HERON GATE 5

IBI GROUP Suite 400 – 333 Preston Street Ottawa ON K1S 5N4 Canada tel 613 225 1311 / 613 241 3300 fax 613 225 9868 www.ibigroup.com	
PROJECT Heron Gate 5	
PROJECT NO: 135142	
DRAWN BY: D.D./S.L.	CHECKED BY: D.C.
PROJECT MGR: J.I.M.	APPROVED BY: J.I.M.
SHEET TITLE REMOVALS	
SHEET NUMBER C-REM	ISSUE

C-400

SHEET TITLE
SANITARY DRAINAGE AREA

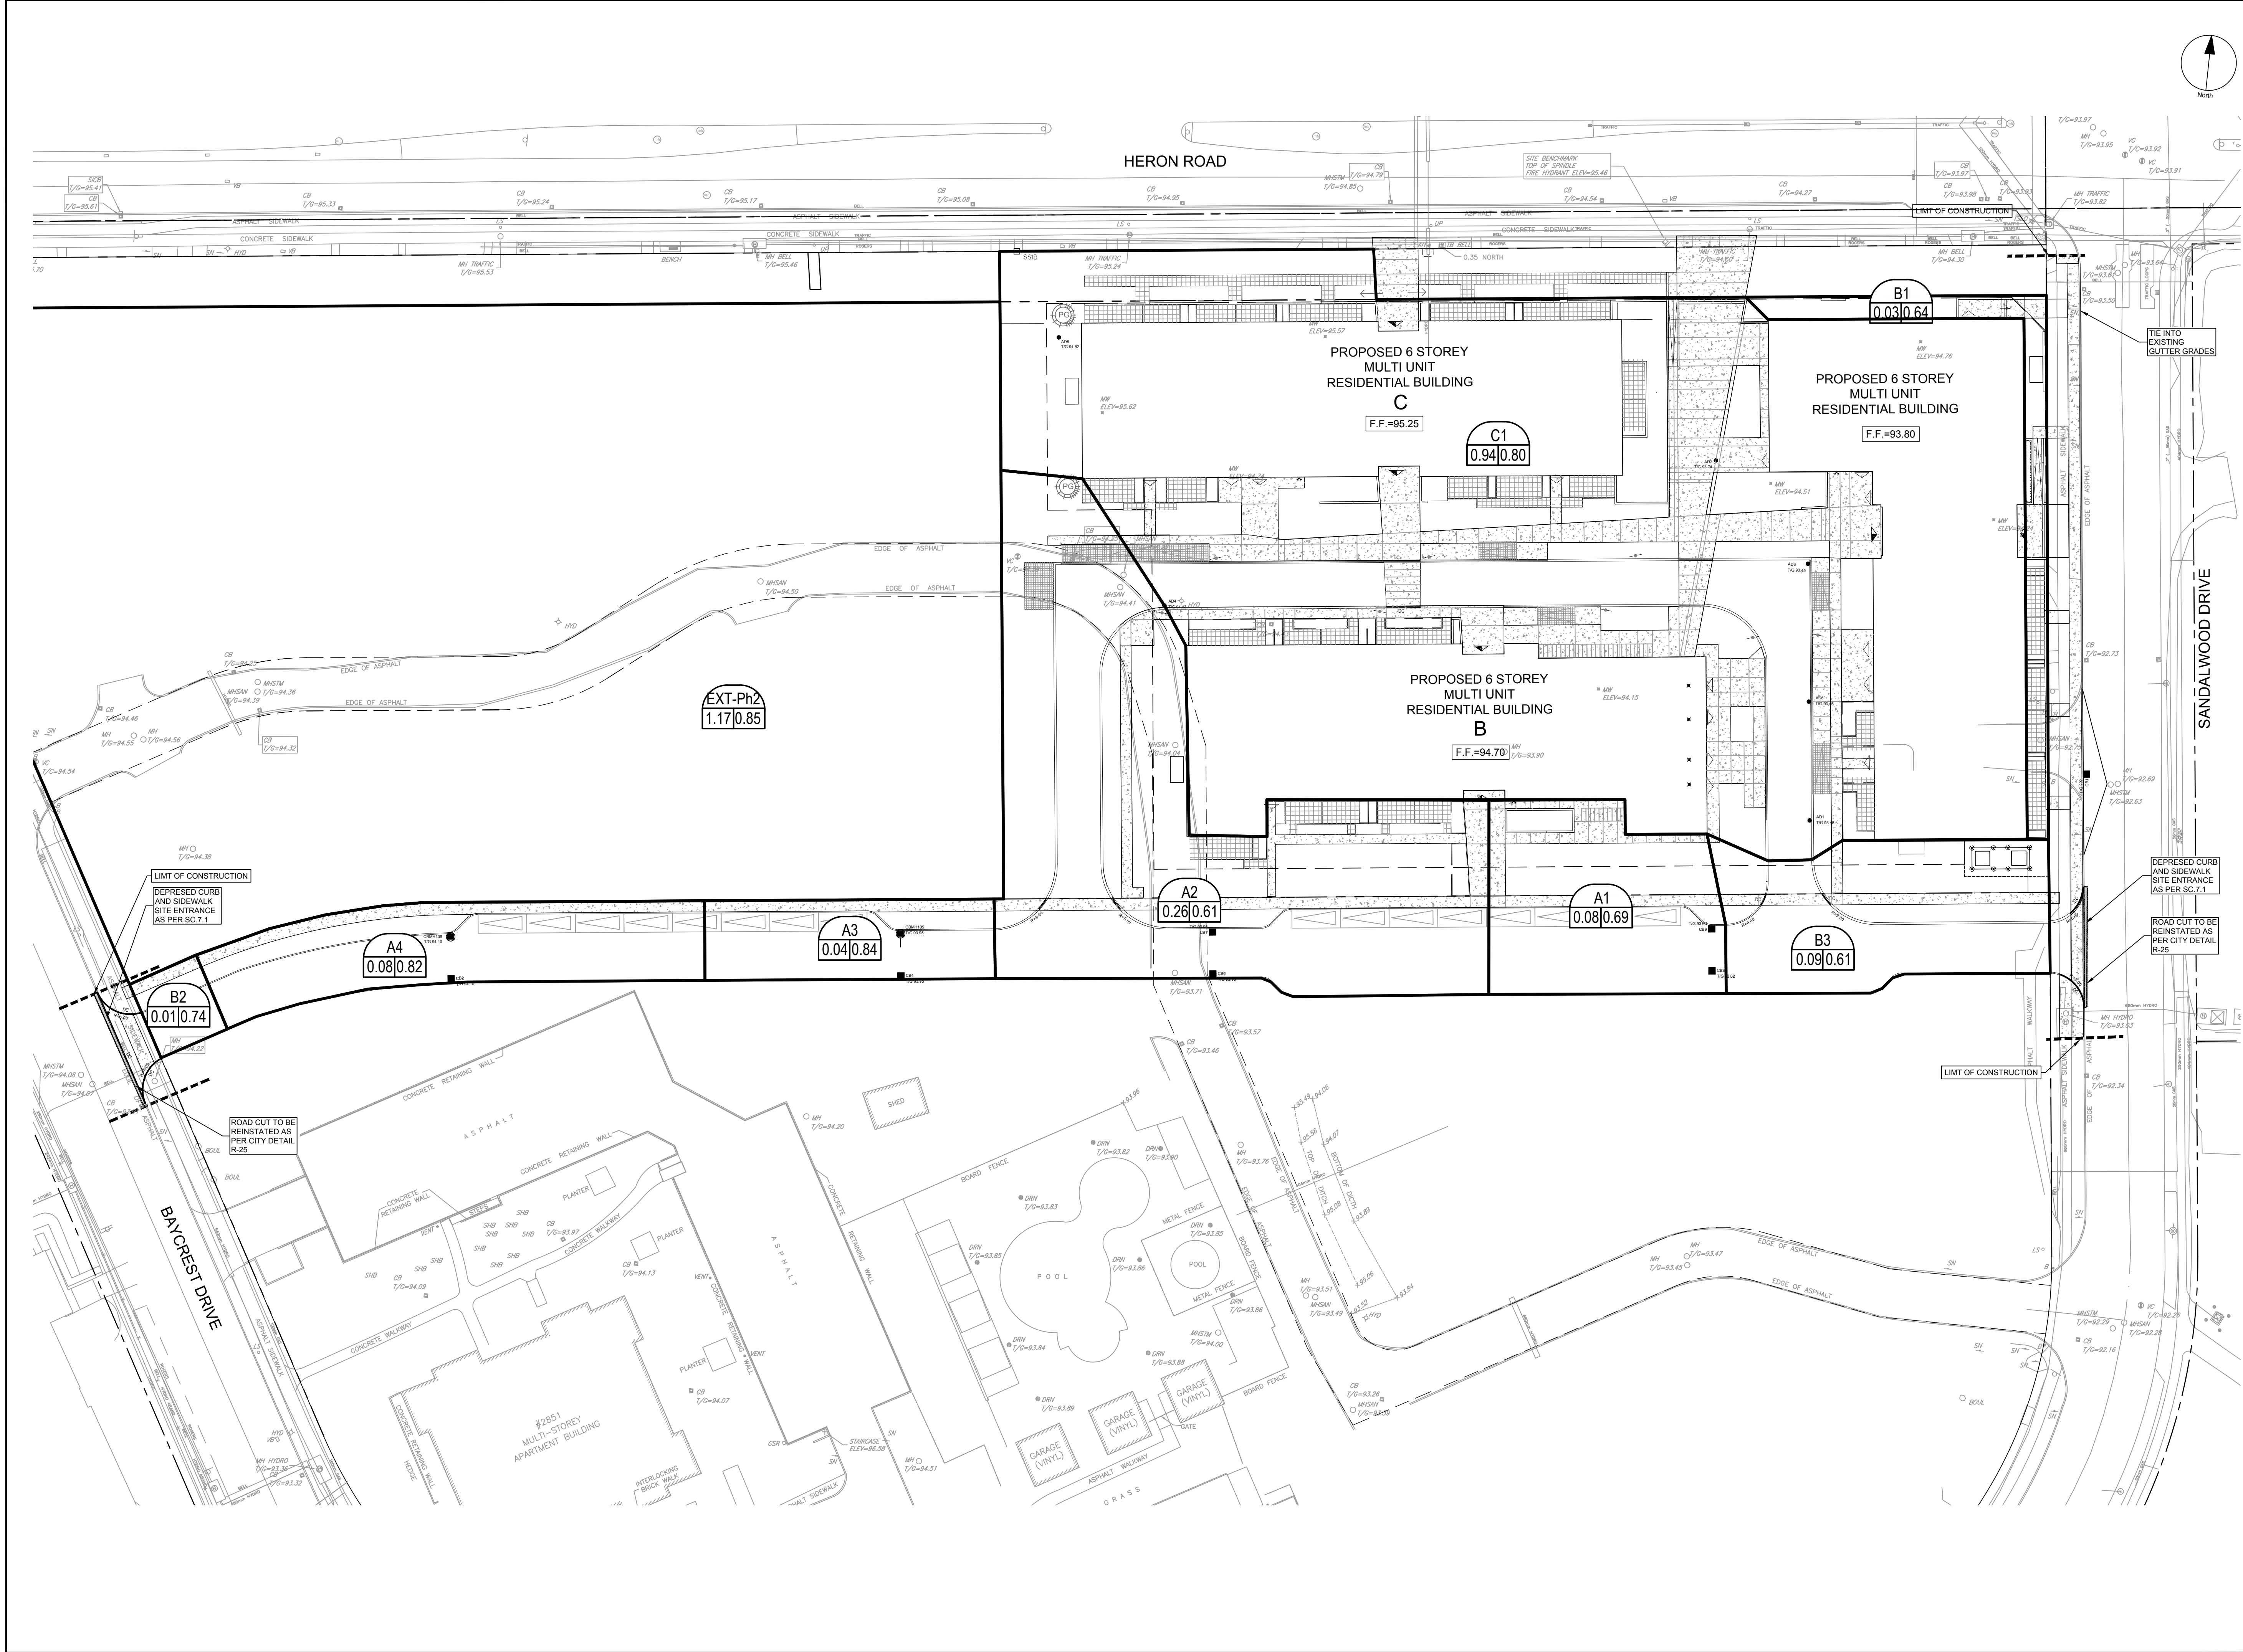
Drainage Area C1 appears to be outside the property lines of the proposed development. Please clarify the rationale for the approach.

IBI: Grading in this area has been revised to provide positive drainage from PL to ROW. Drainage area line revised.
